Our Ref: 21/02570/FULL

Application No: 21/02570/FULL
Proposal: External alterations to dwellinghouse
Address: Eastholme New Road Falkland Cupar Fife

DRAWING NO:	DATE:	STATUS:	SCALE :
			1399 02	09.08.2021	PLANNING	1:100 @ A3

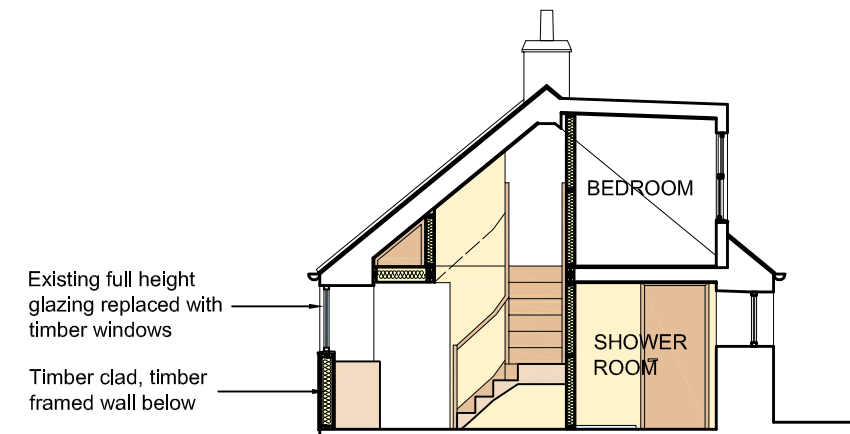
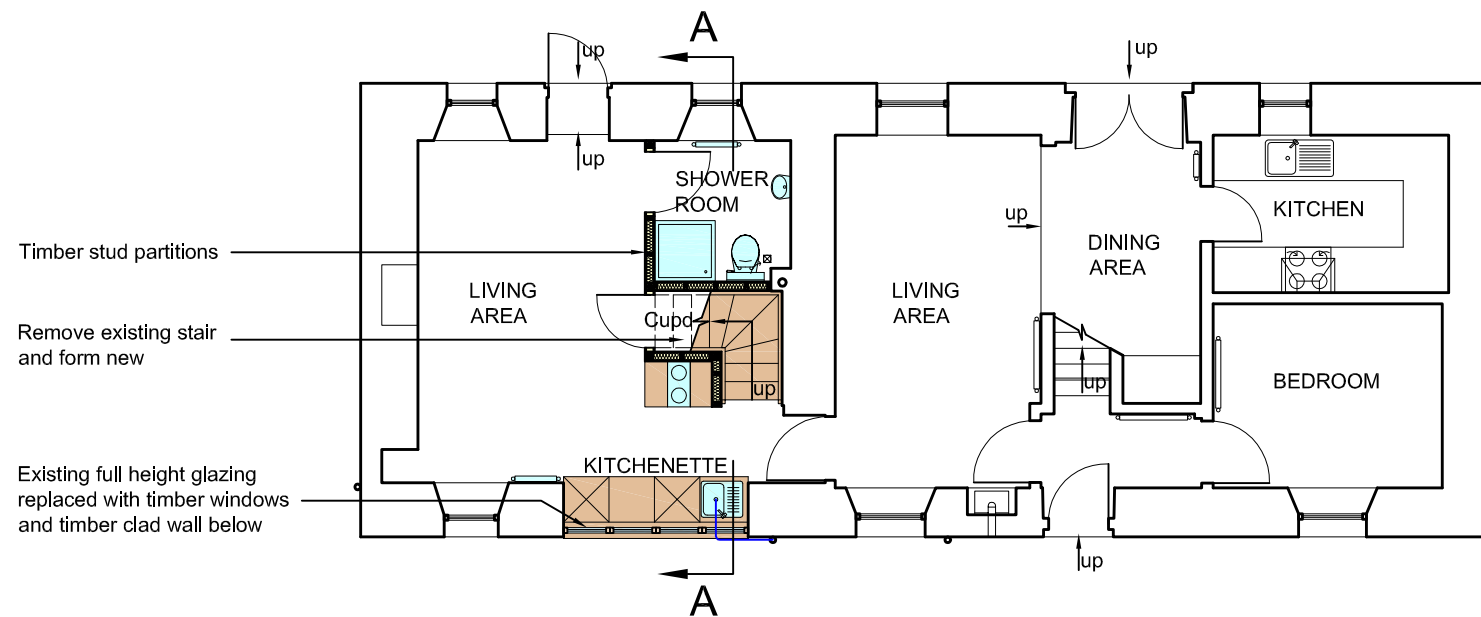
1. Your application did not contain a scale bar to allow the drawings to be calibrated. Please submit replacement elevations and floorplans (existing and proposed) with an accurate scale bar annotated.
